Application No: Y/36/22/HH

Site Address: Berri Court Main Road Yapton BN18 0ED

Description of works: Erection of detached workshop, gym/hobby and greenhouse. This application affects character and appearance of the Main Road/Church Road Yapton Conservation Area and a Listed Building.

Response to Y/36/22/HH

Roof Plan scale 1:50

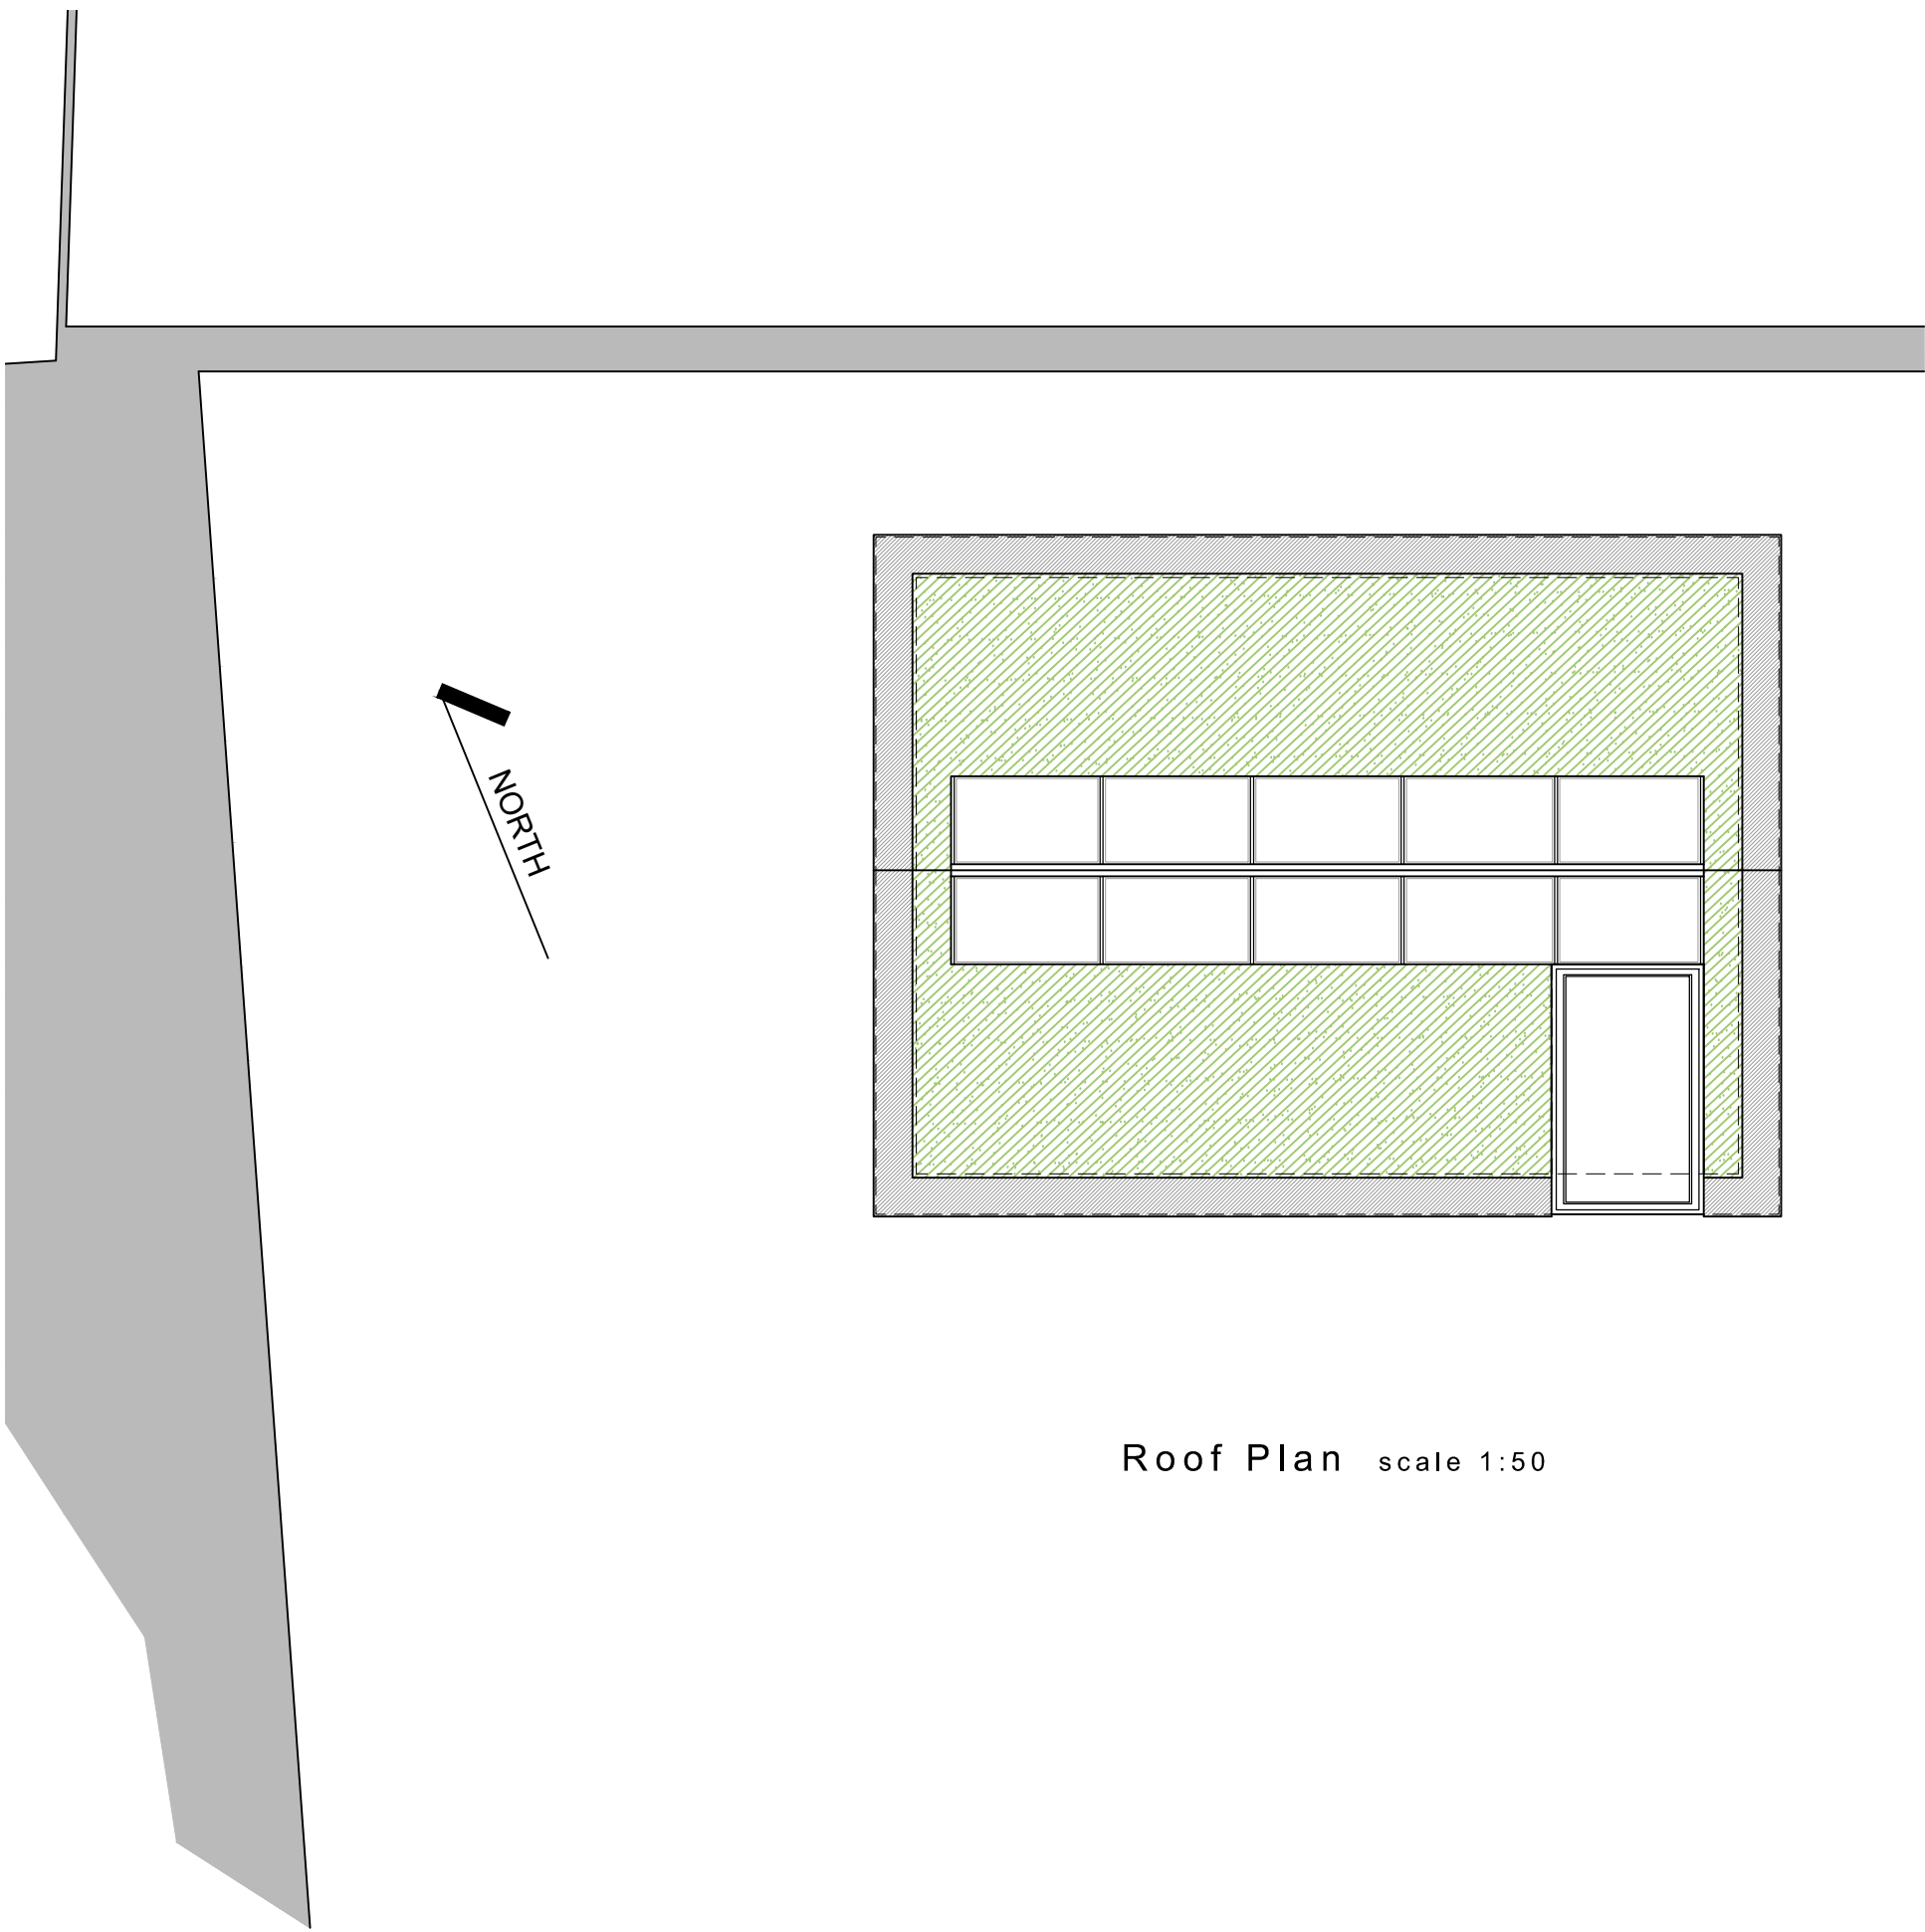
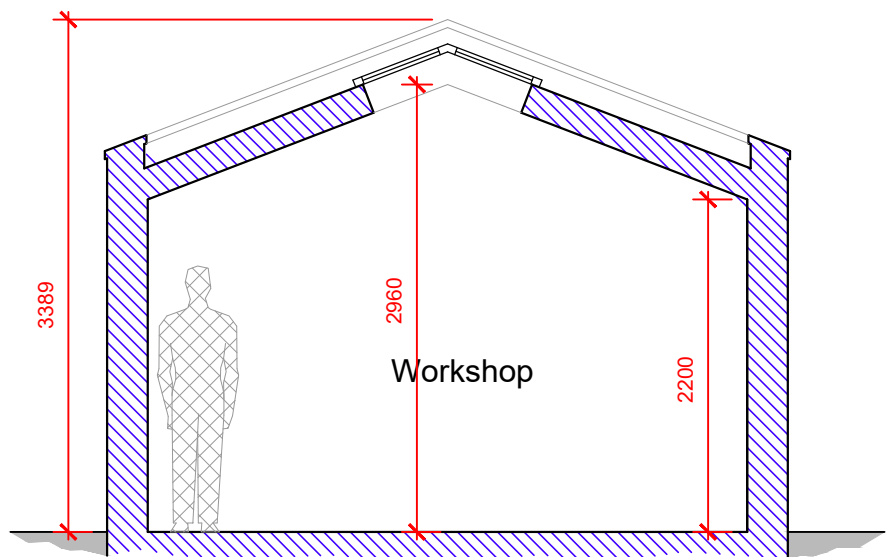
2. Proposed workshop (drawing BR/497/06) - YPC fail to understand how this structure relates to either the proposed heritage greenhouse or indeed the main listed building. YPC have concerns relating to the proximity of the proposed workshop to the main dwelling. The proposed structure jars against the listed building and has no relationship with either the proposed heritage greenhouse or indeed the listed building. YPC note that the suggested materials neither enhance or blend with the listed building or its setting and significant boundary walls. YPC object to the siting and design of the workshop.
